Submissions Report

Punchbowl, Affordable Housing, State Significant Development

150 The Boulevard and 34 Dudley Street, Punchbowl

SSD-83256463

Drawing Title Section 1 and 2

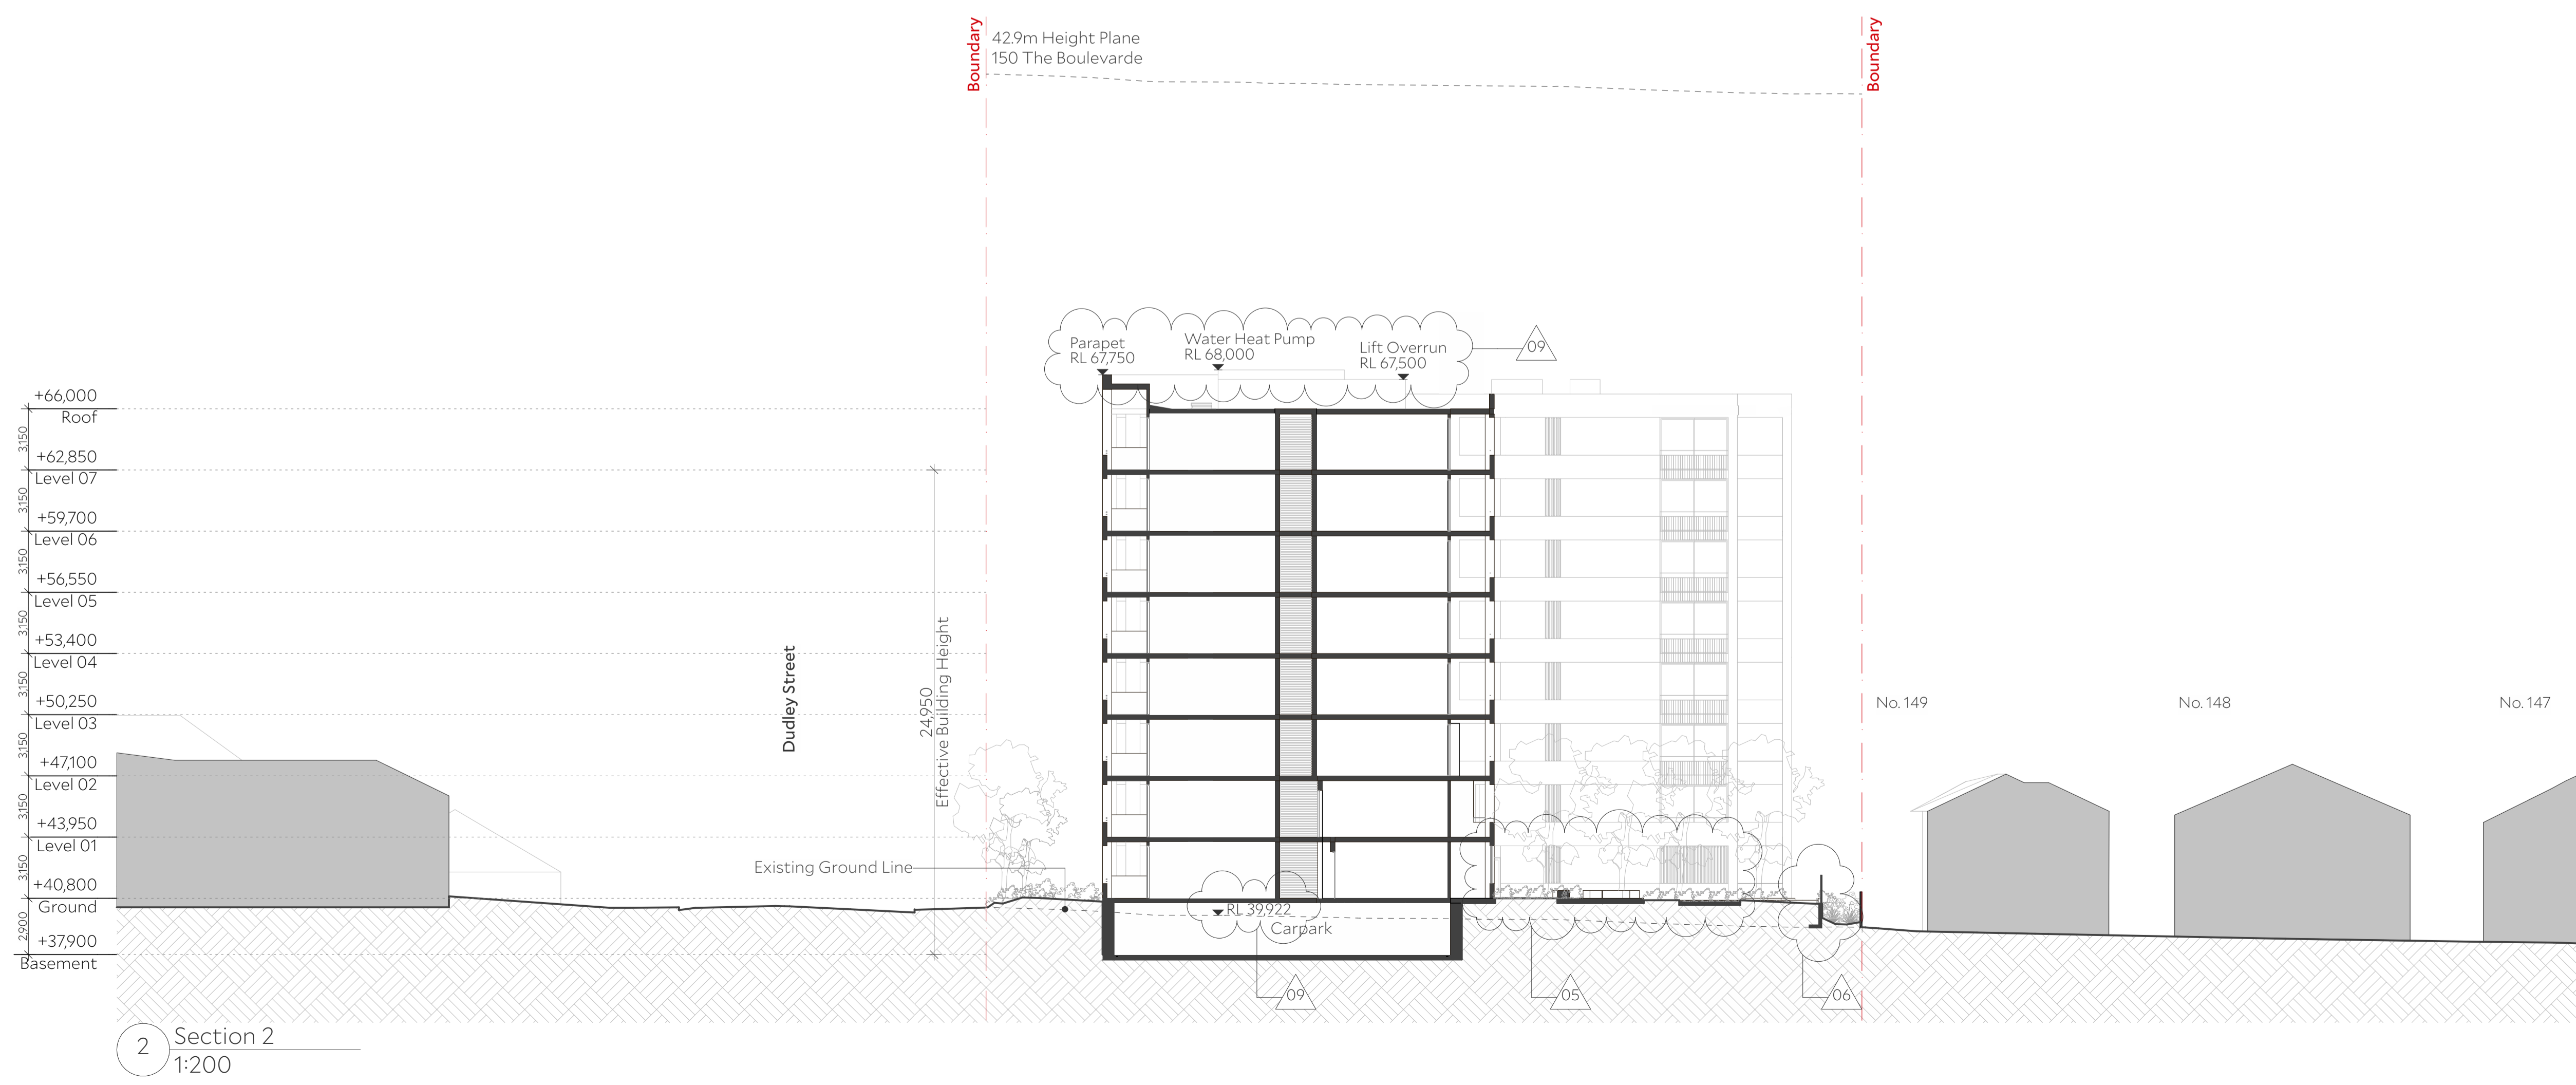
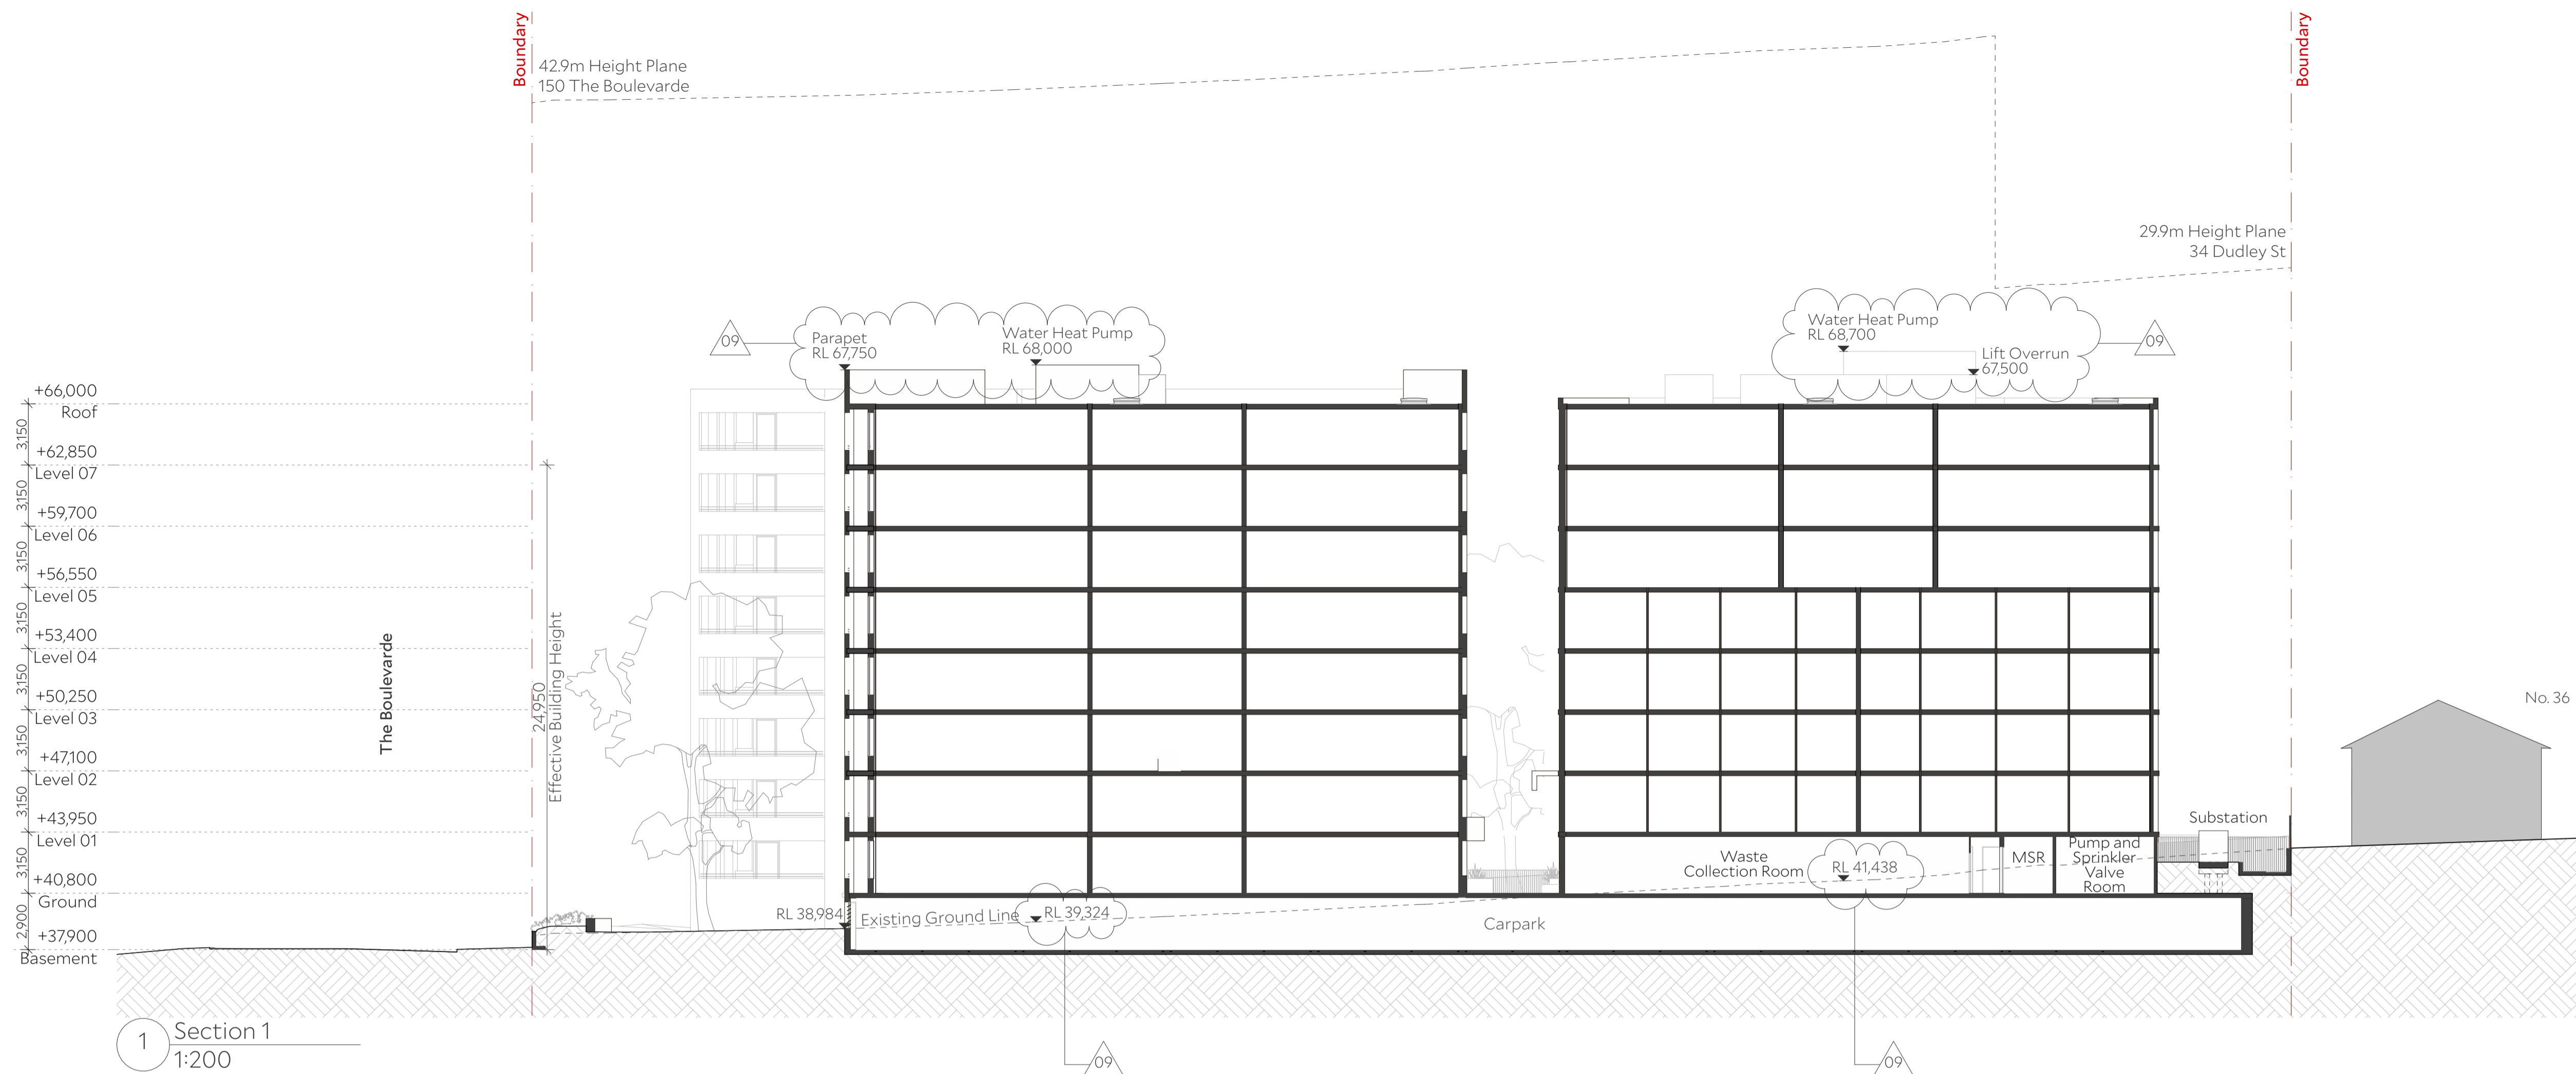
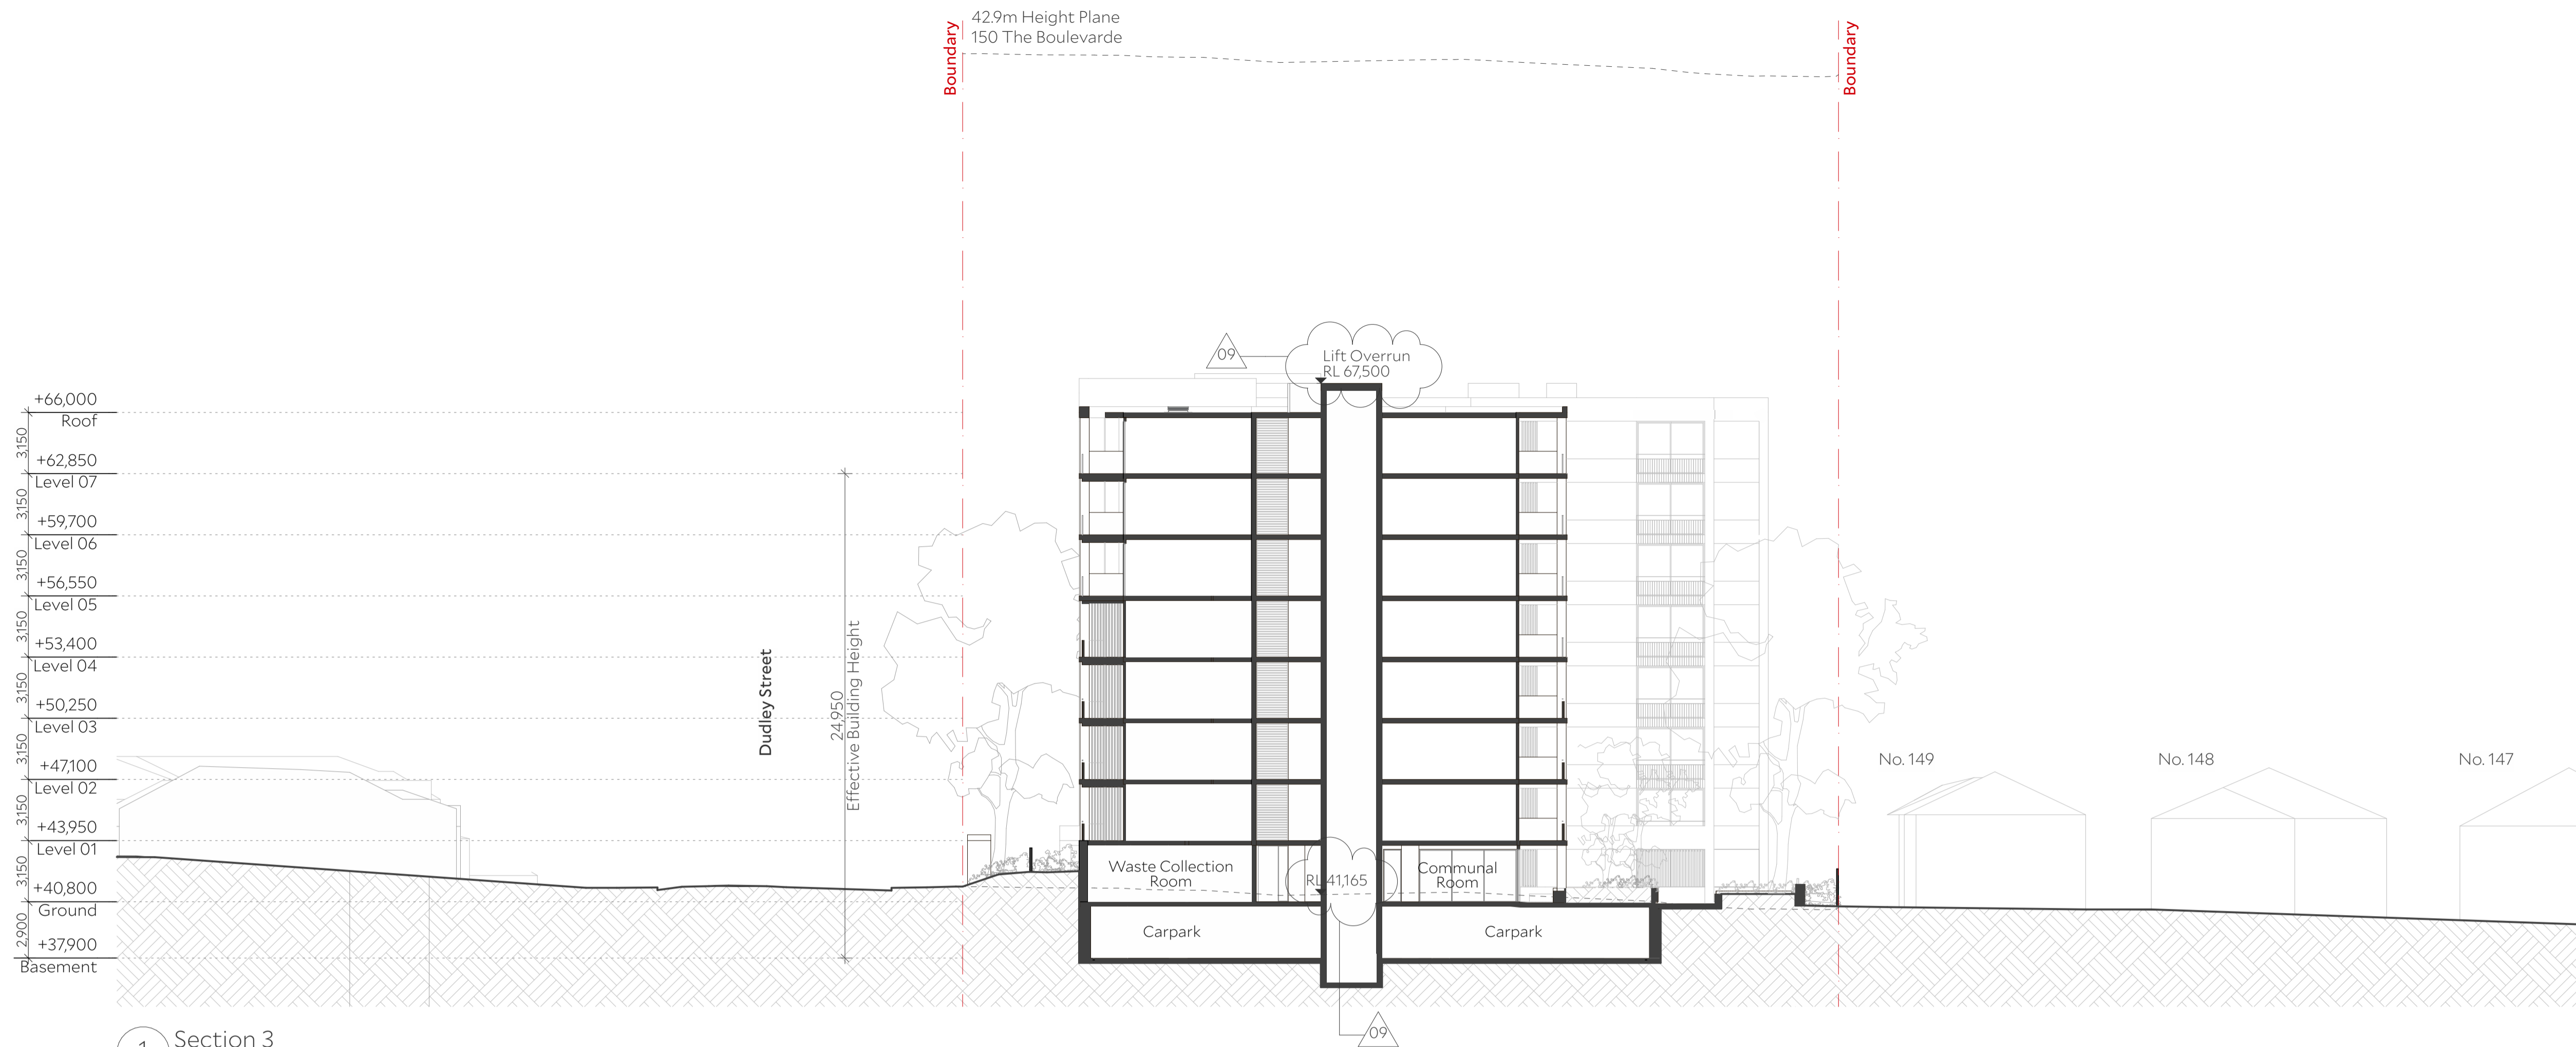
6.2	To enable the Department to verify building height, provide updated section plans which include Reduced Levels (RLs) for the maximum height of the development (including rooftop services) and the existing ground level immediately below.	Section drawings have been updated to include the RLs for the maximum height of the development including rooftop services and the existing ground level. Refer to updated Architectural Plans at Appendix B.
